**Re: Request for a Review of a Declaration (reference ED 421) (register reference 1523) by  
Kyran Hurley Chairman of the Management Board, Carrowhubcock Village Enniscrone, Sligo**

Re: Request for a Review of a Declaration (reference ED 421) by Sligo County Council under Section 5 of Planning and Development Act 2000 (as amended) regarding a raised timber deck and surrounding boundary fences and supporting pillars constructed at the front (west side) of 41 Carrowhubbock Village, Enniscrone, Co. Sligo (register reference 1523)

### Grounds of Appeal Submission to An Bord Pleanala<sup>1</sup>

PL 1523 EXTRACT GROUND FLOOR PLAN 2019

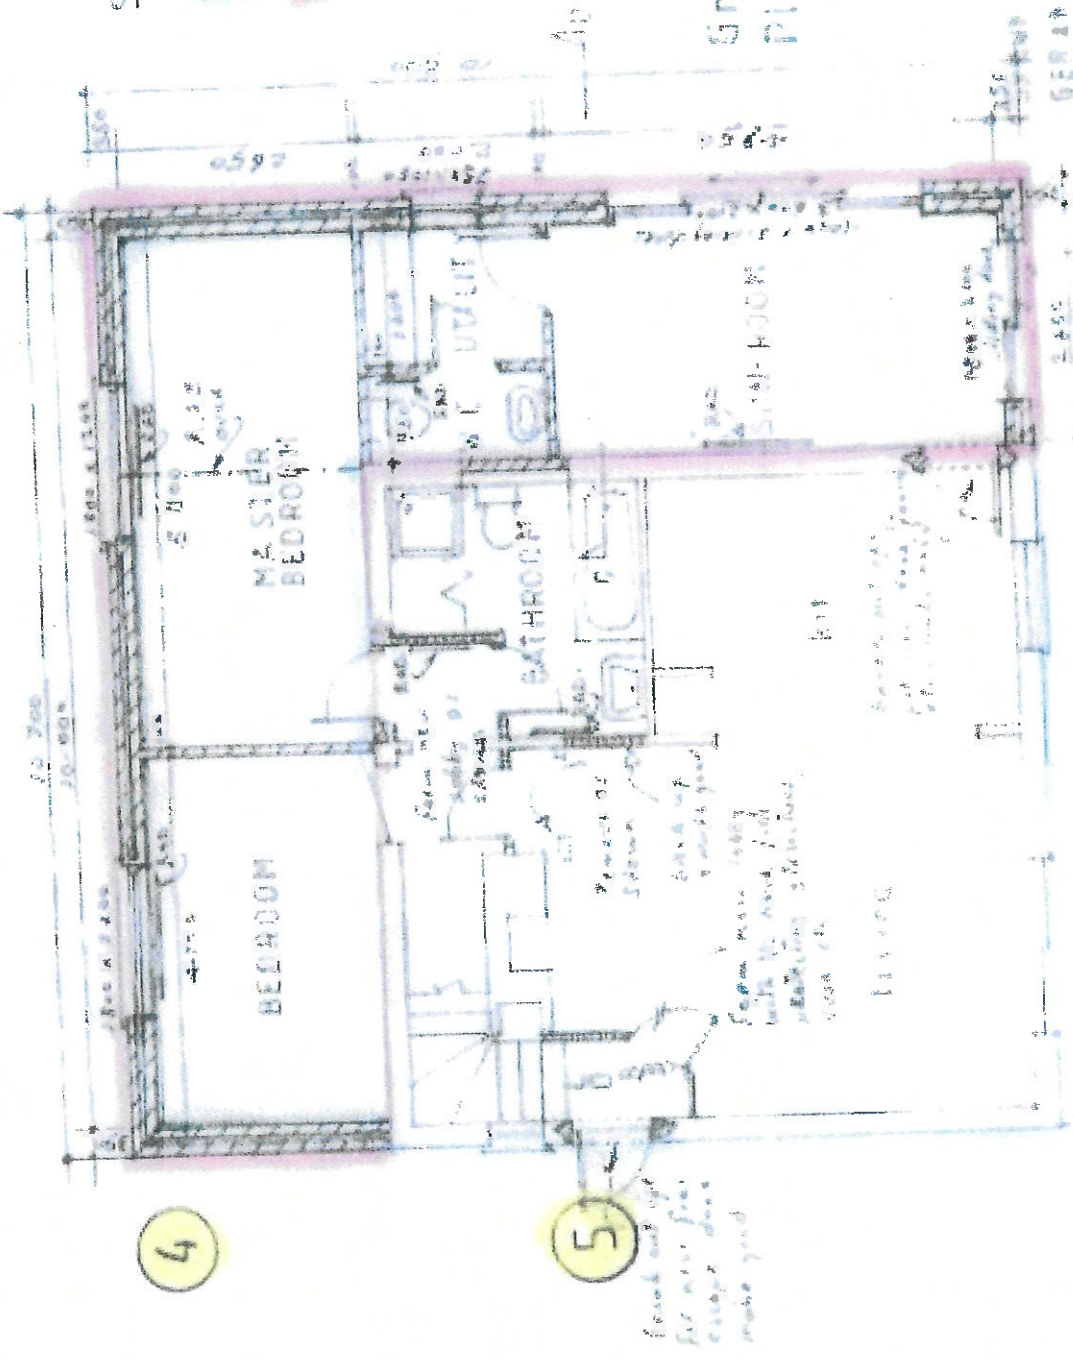
The “minor amendments/alterations” drawings include a Ground Floor Plan with a shaded area on the west side<sup>12</sup> with a note of “proposed timber decking”. The alteration marked 3 refers to the removal of external stairs and not to the timber decking. The side elevation<sup>13</sup> has a note stating “fit timber decking”. No above ground construction (balustrade or fence) is shown on the elevation and there is nothing to indicate that the proposed deck was to be raised above ground level nor that it would have surrounding walls. No construction details were included to indicate that it would be other than at ground level. The colouring in the drawings mark the outline of the proposed elements to be constructed in red. The timber decking is not marked in red. There is a detailed section showing the construction details from the existing ground level

5. I have told the board several times that the level of the balcony was drawn at lounge level by our architect ...i.e., the same level as the rest of our extension and that no changes were made to this in 2019 apart from the stair case being removed. We can see the level clearly on the drawings. The management board asserted in one of their letters to the Council that these drawings were not available for viewing during the planning stage. This worried me but on checking with the council I was assured that the decking drawings were included for viewing.

Front (west)

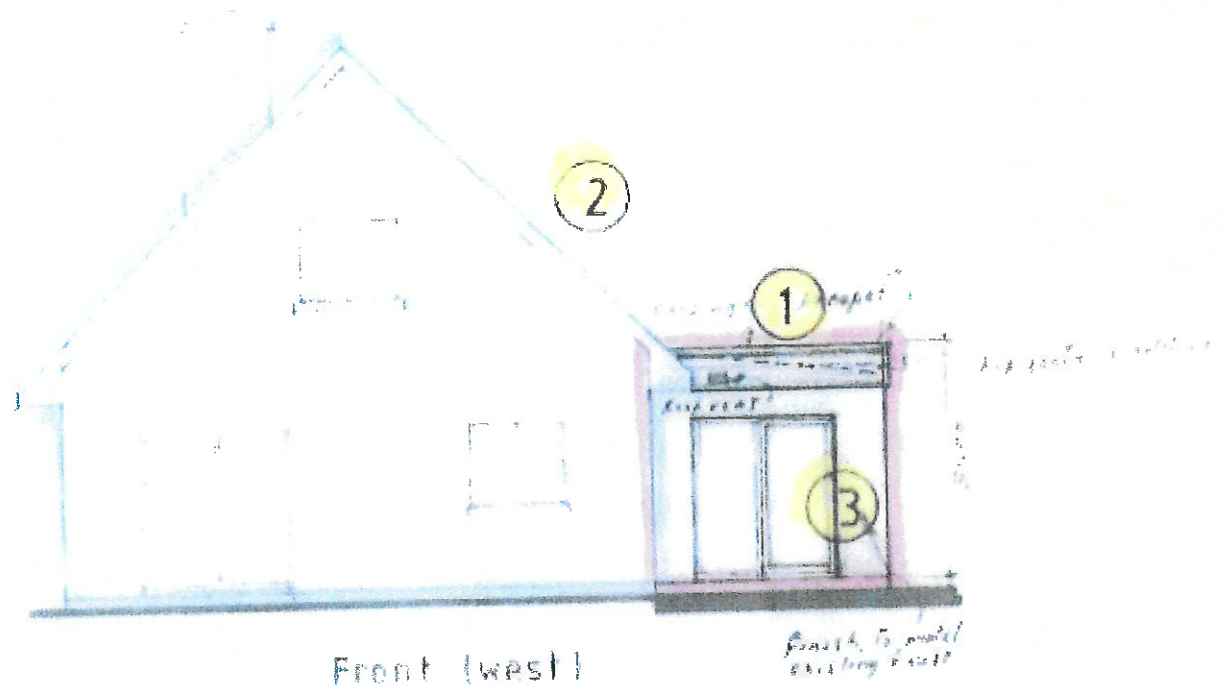
The front elevation showed the external stairs including trellis cladding/planting. However as noted above no raised decking or fencing around the stair was shown on the front elevation drawing. The only vertical
